Response to Planning Application

From: Arun District Council Greenspace

Application ref: R/298/21/P

Description: Erection of a drive-thru coffee shop (Use Class E) with associated parking, service arrangement, landscaping and associated infrastructure. This application is in CIL Zone 4 (zero rated) as other development.

210-002 P2

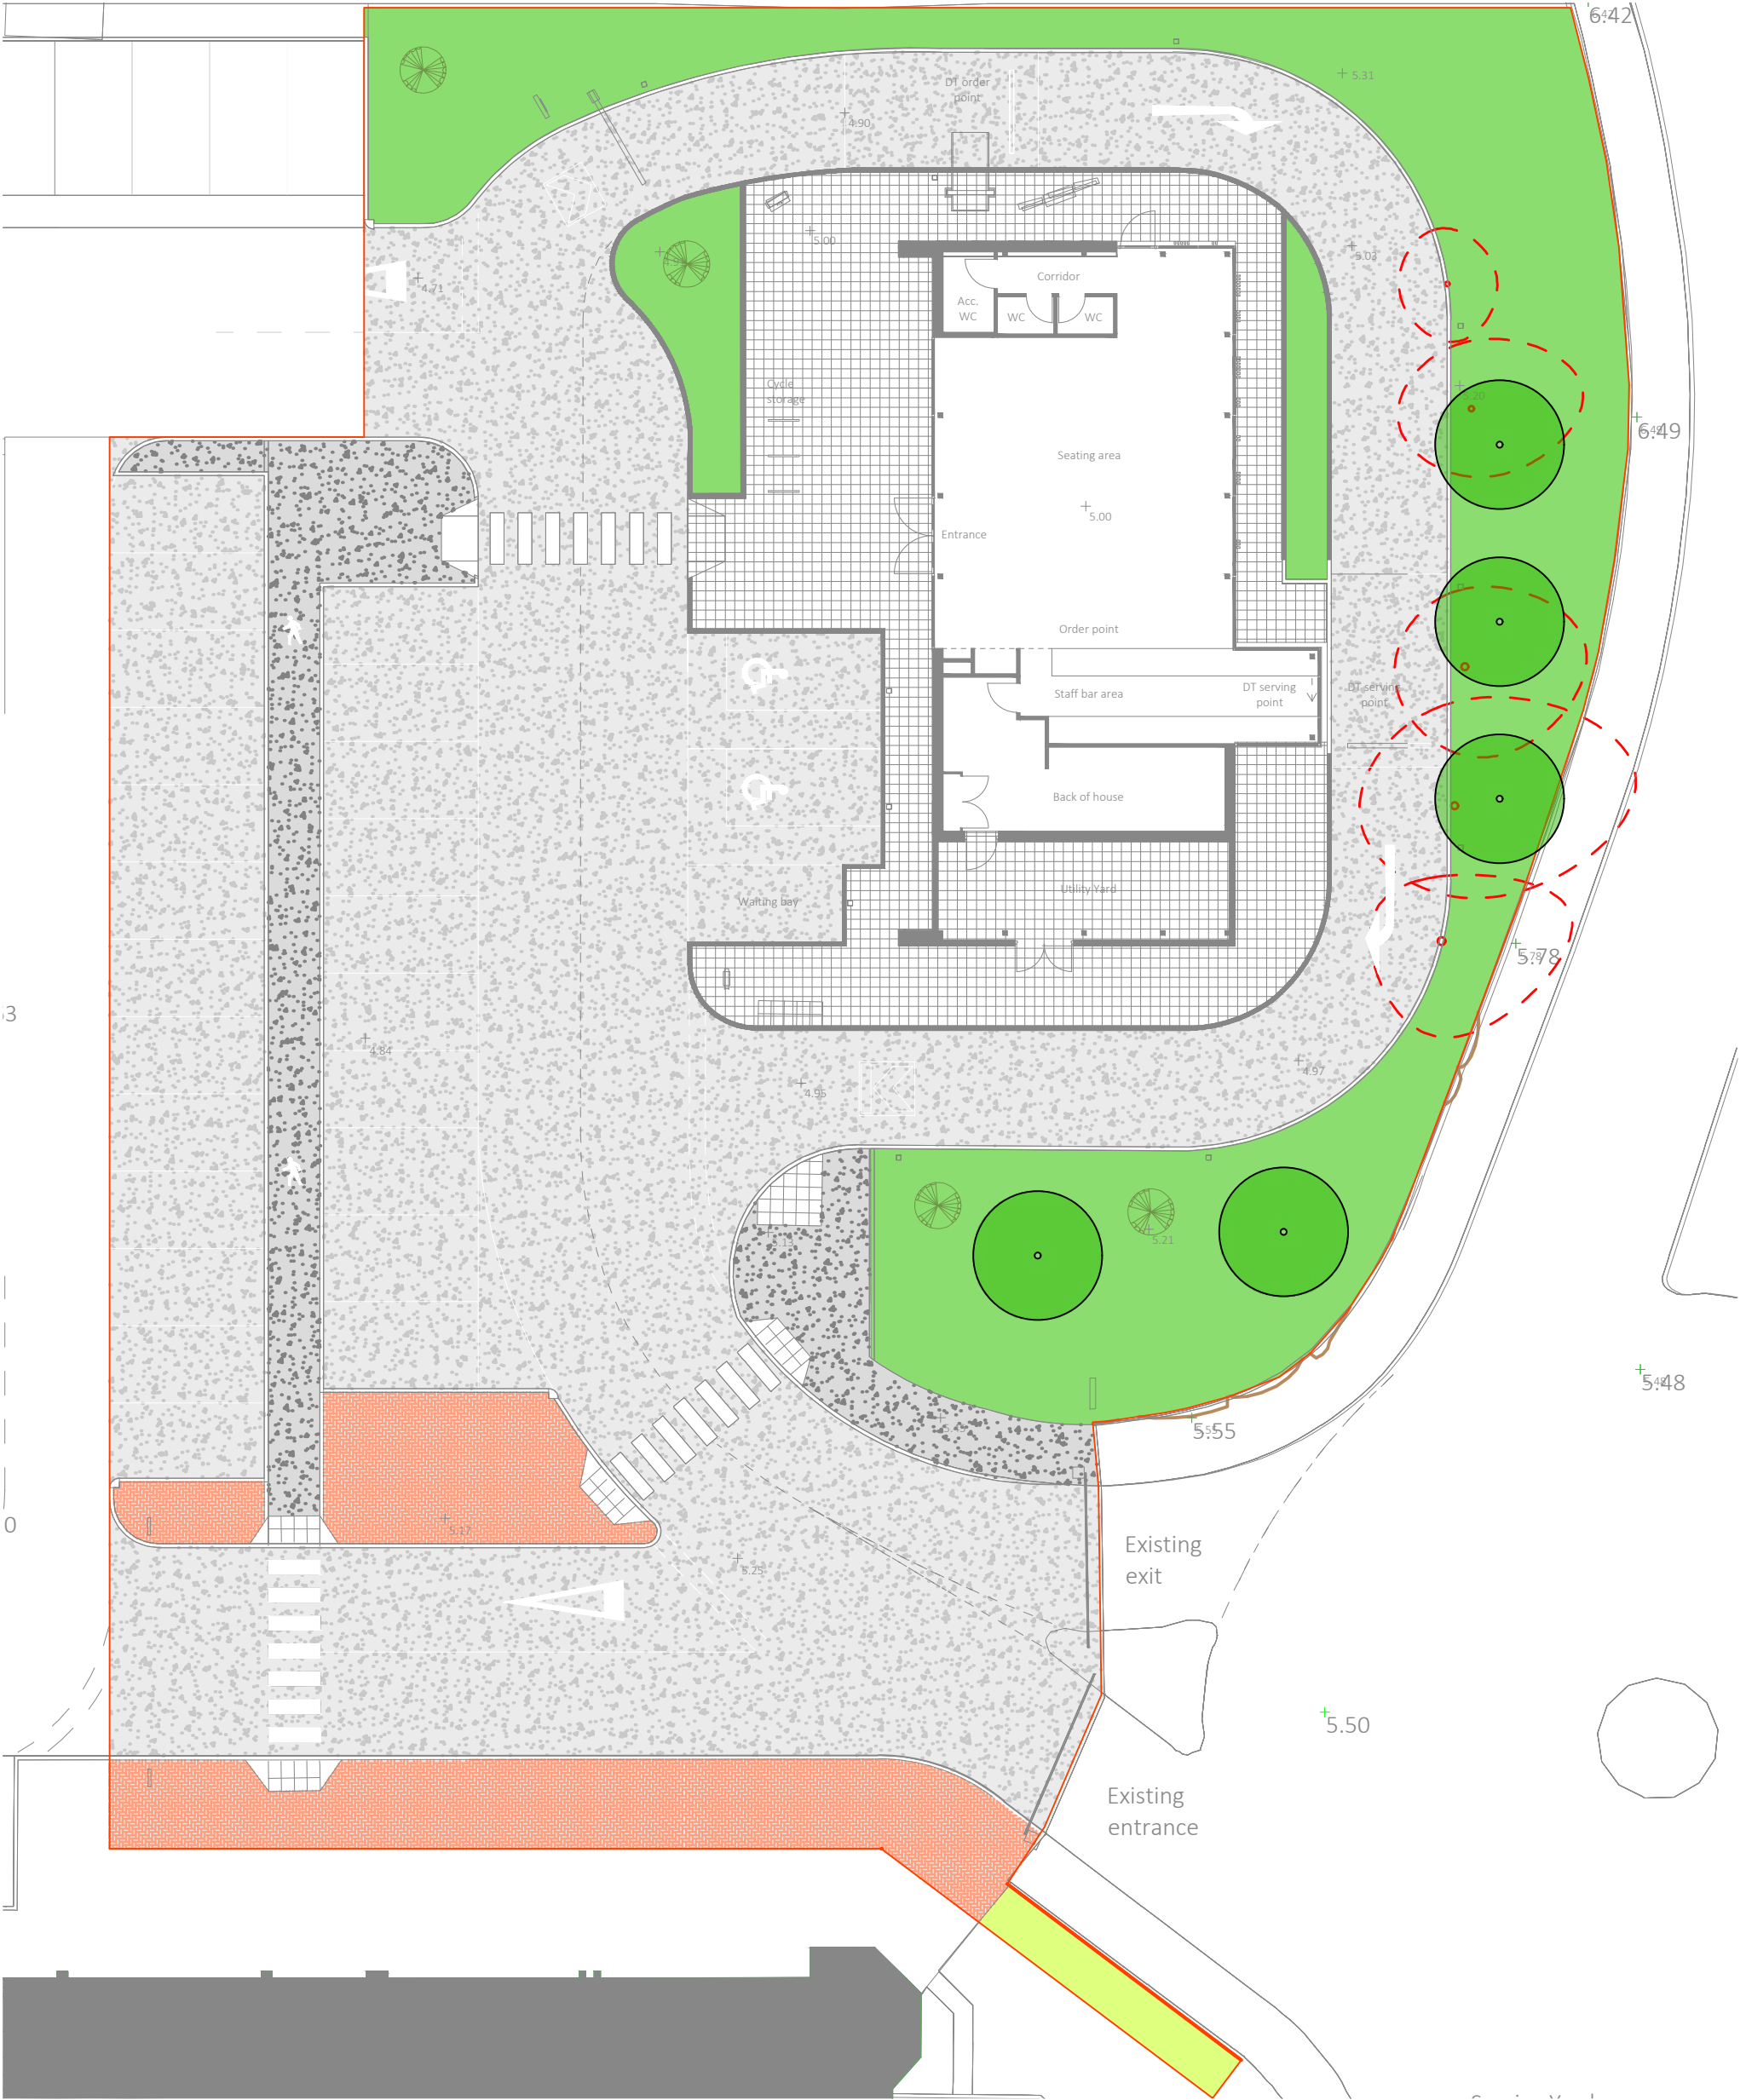
The Landscape strategy and DAS have indicated that there would be the need to remove 5no existing trees to undertake the proposals. (Any proposed tree removals should be in consultation with the LPA Tree Officer) The removal of these would only be supported if mitigation planting were provided for betterment in this location. 5no trees of ornamental species are proposed as replacements as part of these works, these are show to be planted at an acceptable size.

The information shown in Landscape Plan Dwg No 210-002 Rev P2, Planting Plan Dwg No 210-201 Rev P2 and Plant Schedule 210-SCH-001 have provided information of landscaping which in general would provide and increased ornamental offer in this location. Further detail will need to be provided in plan form showing actual quantities in location for the planting mixes rather than percentage mix. Mix B and Mix C will provide ornamental addition only and due to their low growing habit will not provide screening to the development, advise that the species mix of Mix B and Mix C are amended to provide further structured planting.

Planting Mix B and Mix C will provide ornamental addition only due to their low growing habit and not provide structure to the development, advise that the species mix of Mix B and Mix C are amended to provide further structured planting.

Recommend no landscape objection to the proposals as presented under this application R/298/21/PL – further detail to be submitted for approval and minor amend re species advised as above.
